STATE OF NORTH CAROLINA
DEPARTMENT OF TRANSPORTATION

July 24, 2020

Subject: **Modification Request for Section 404 Individual Permit, Section 401 Water Quality Certification and Neuse Riparian Buffer Authorization** for Interstate 40 Widening and Improvements from I-440/US 64 (Exit 301) to just north of SR 1525 (Cornwallis Road), including improvements to NC 42 and SR 1010 (Cleveland Road) in Wake and Johnston Counties, Federal Aid Project No. IMNHF-040-4(139)301; TIP Numbers I-5111 and I-4739, Division 5. Debit \$570 from WBS Element 42346.3.1.

PERMIT DRAWING SHEET 91 OF 125

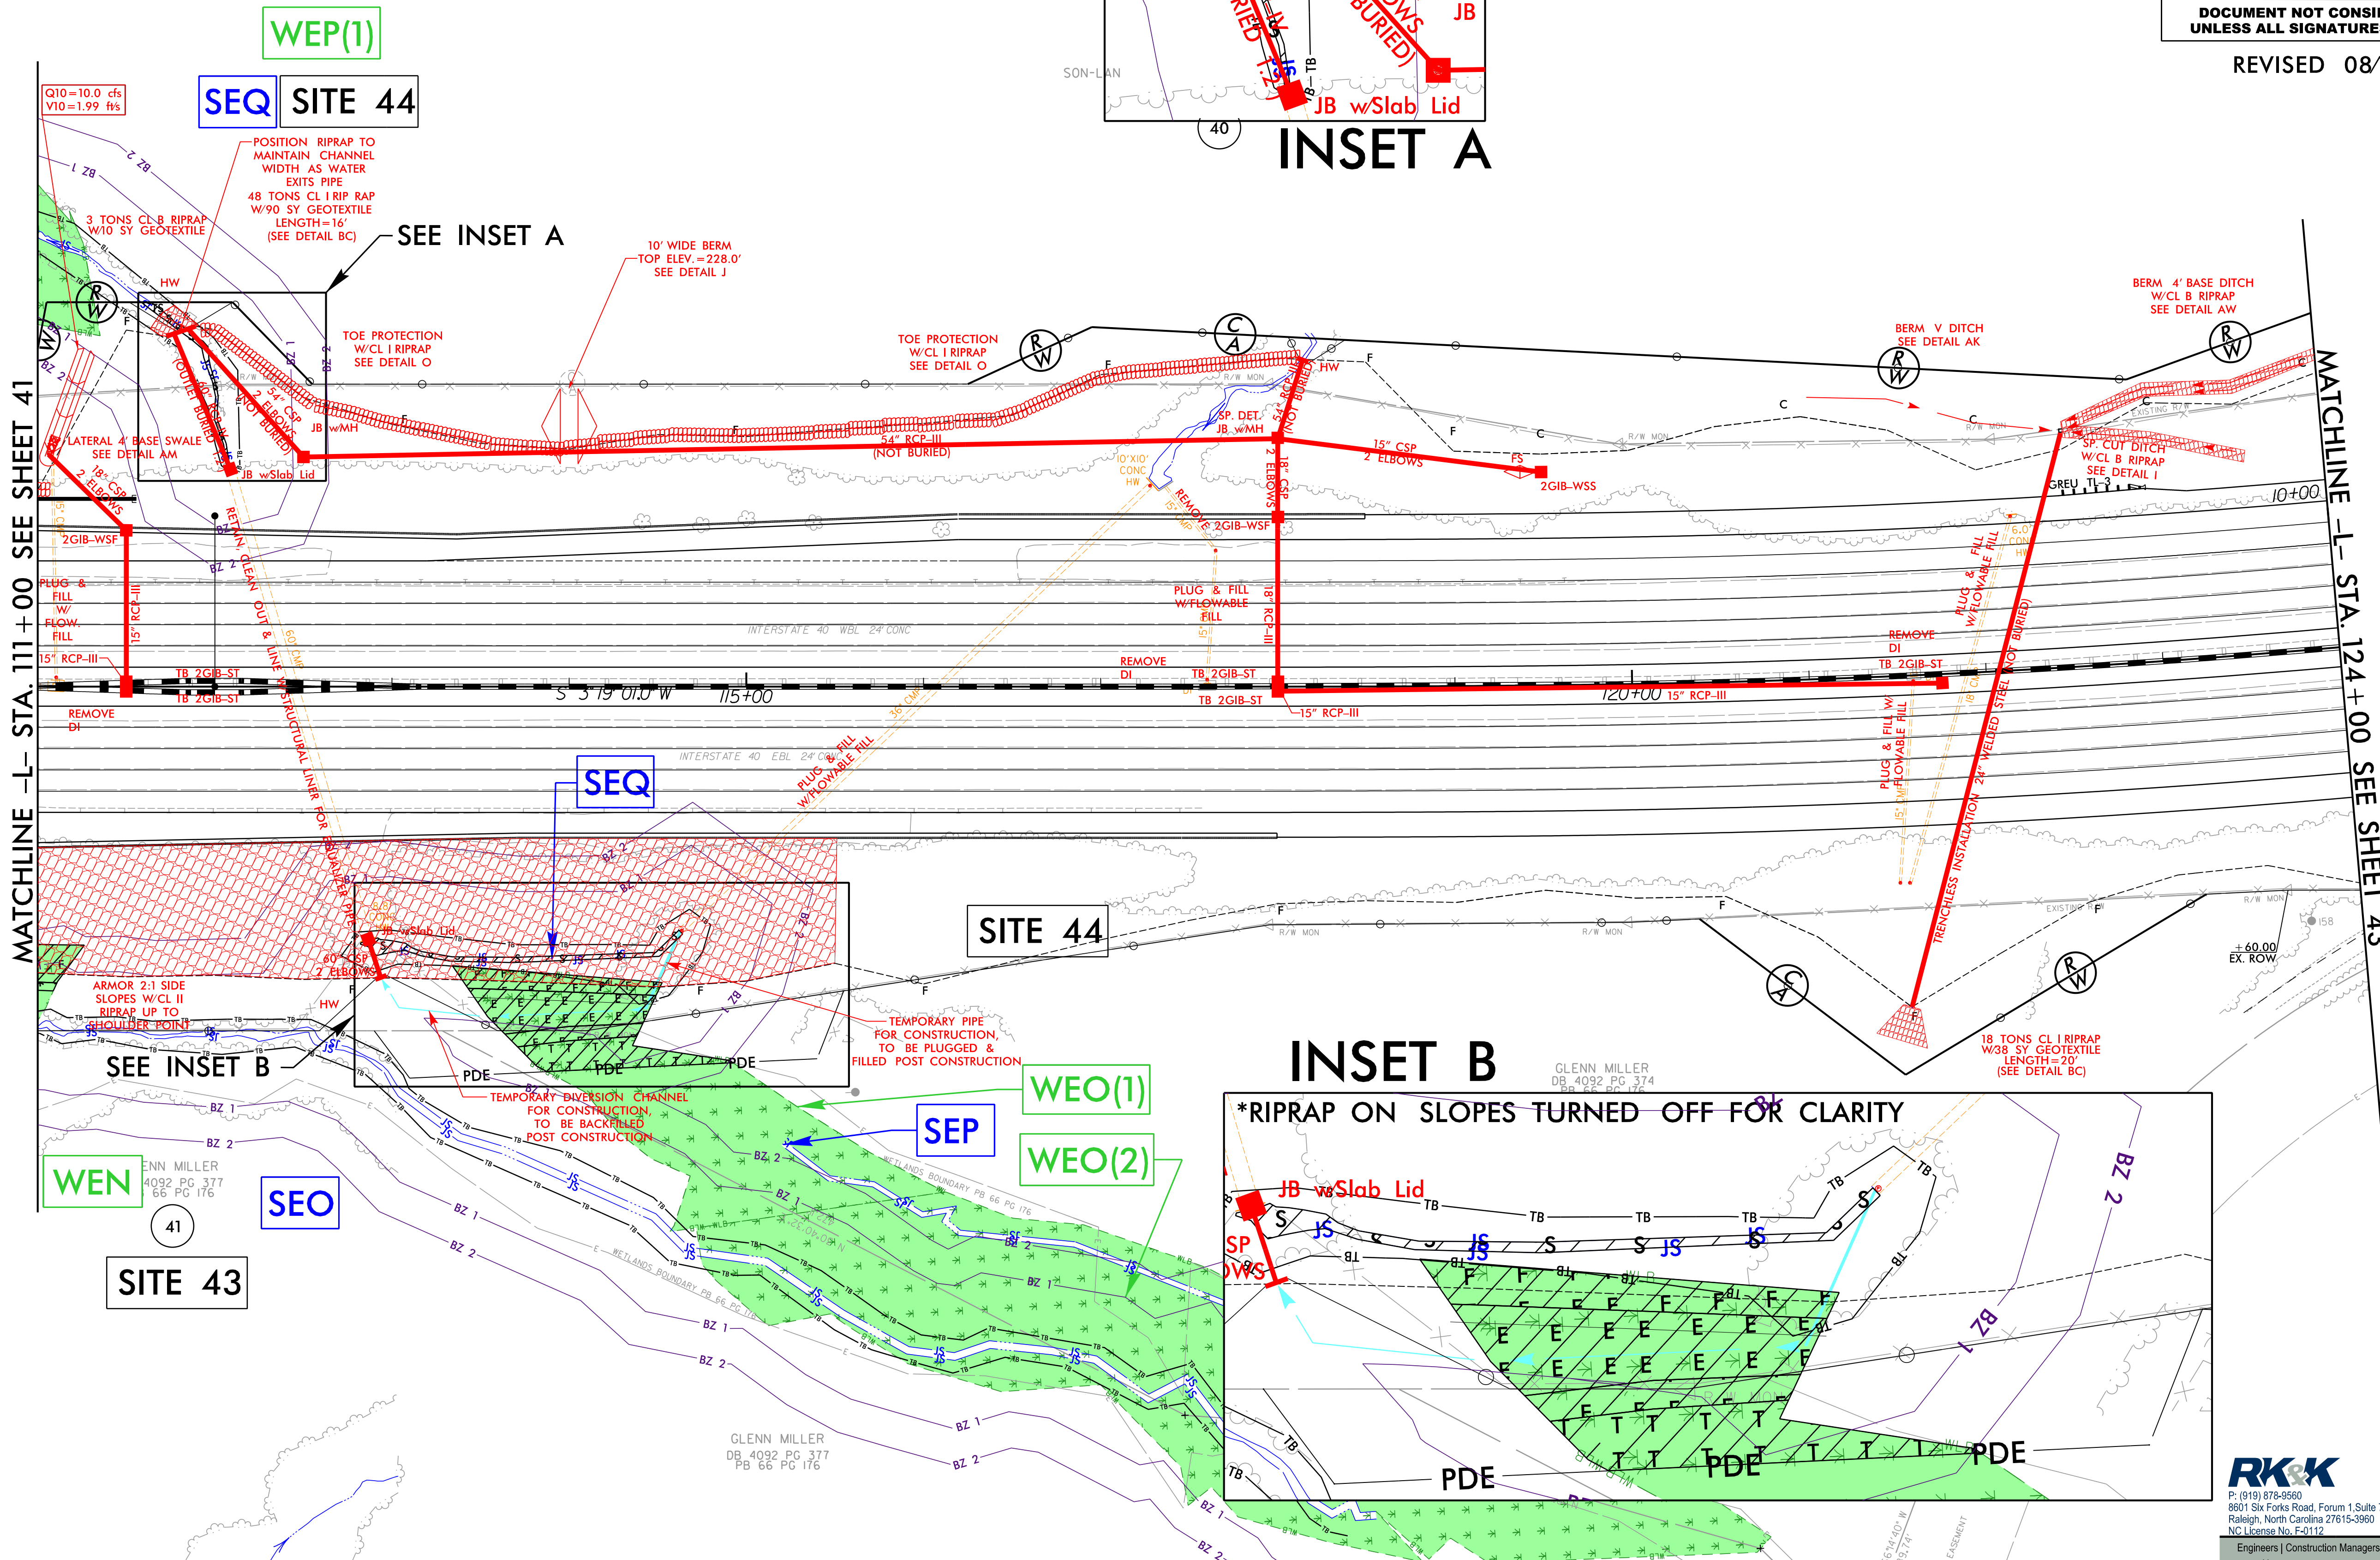
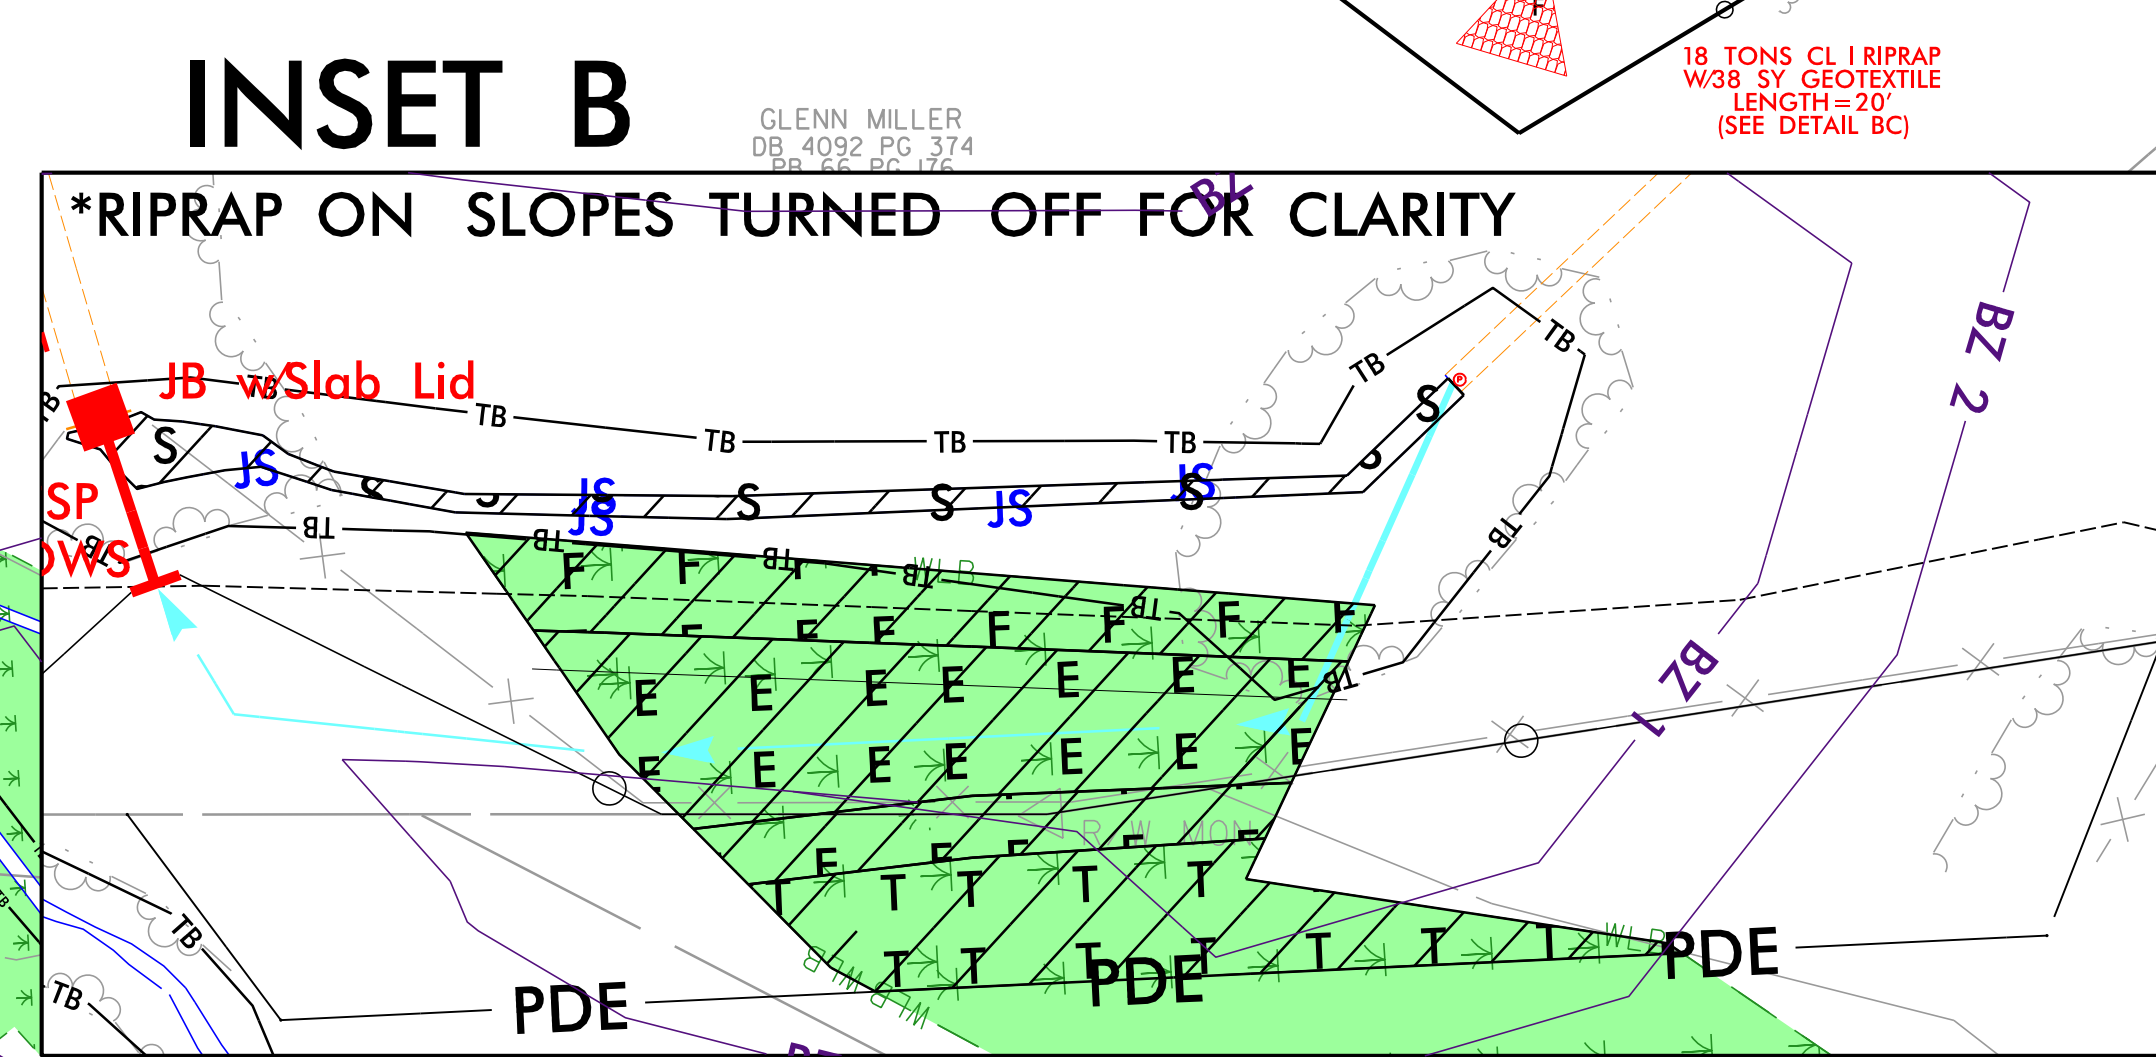
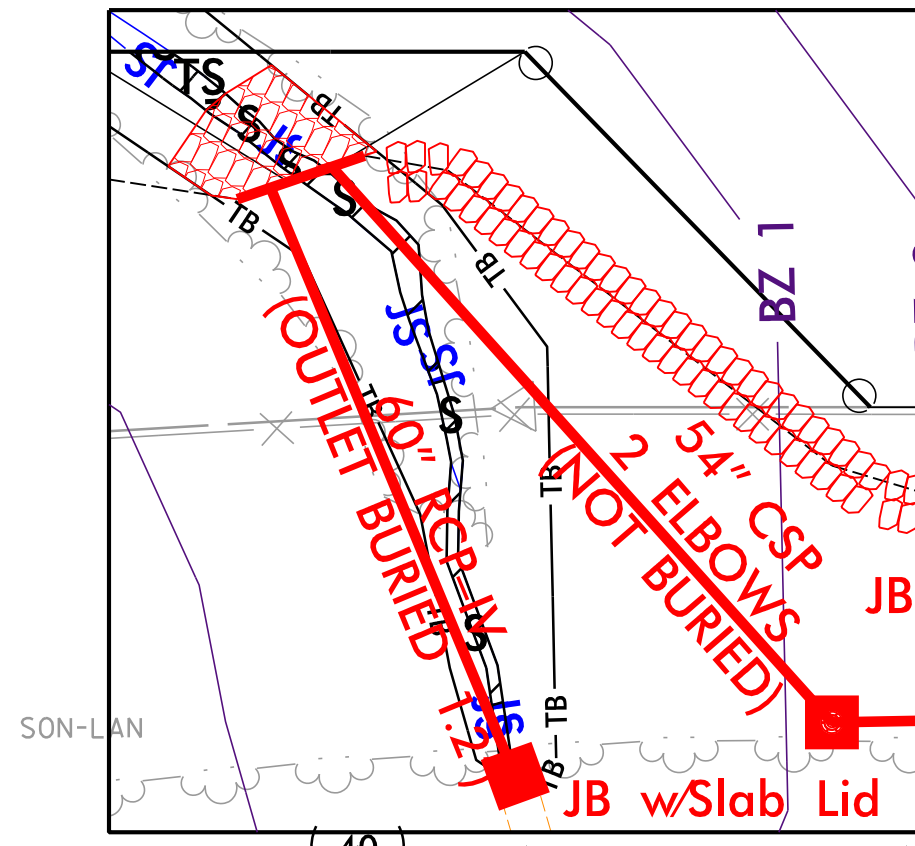
A field revision is being requested at Site 44. Currently, stream SEQ is piped from the east side of I-40 to the west side, travels along the west side of I-40 for approximately 80 feet, then is piped back to the east side. The original design kept the drainage pattern by boring a new 54" steel pipe to the west side of I-40 and then extending the existing 60" pipe to convey SEQ back to the east side. The new design proposes to install a pipe along the east side of I-40 that outlets to the same 60" pipe, thus eliminating the need to bore a new 54" steel pipe. The 60" pipe will still be extended to convey any drainage from the west side to the east as well as to act as an equalization pipe.

This modification will not result in additional surface water impacts as the entire SEQ channel on the west side of I-40 was being relocated and considered fully impacted. Further, by eliminating the channel relocation, changes to jurisdictional impacts are as follows:

Attached are revised permit drawings depicting the affected area, all of which have a revision date of either 7/2/2020 or 7/15/2020. These include the following:

- Permit Drawing 91: plansheet 42 without contours
- Permit Drawing 92: plansheet 42 with contours
- Permit Drawing 93: plansheet 42 profile
- Permit Drawing 124: impact summary table
- Permit Drawing 125: impact summary table
- Buffer Drawing 42: plansheet 42 without contours
- Buffer Drawing 51: buffer summary table
- Buffer Drawing 52: buffer impact summary table
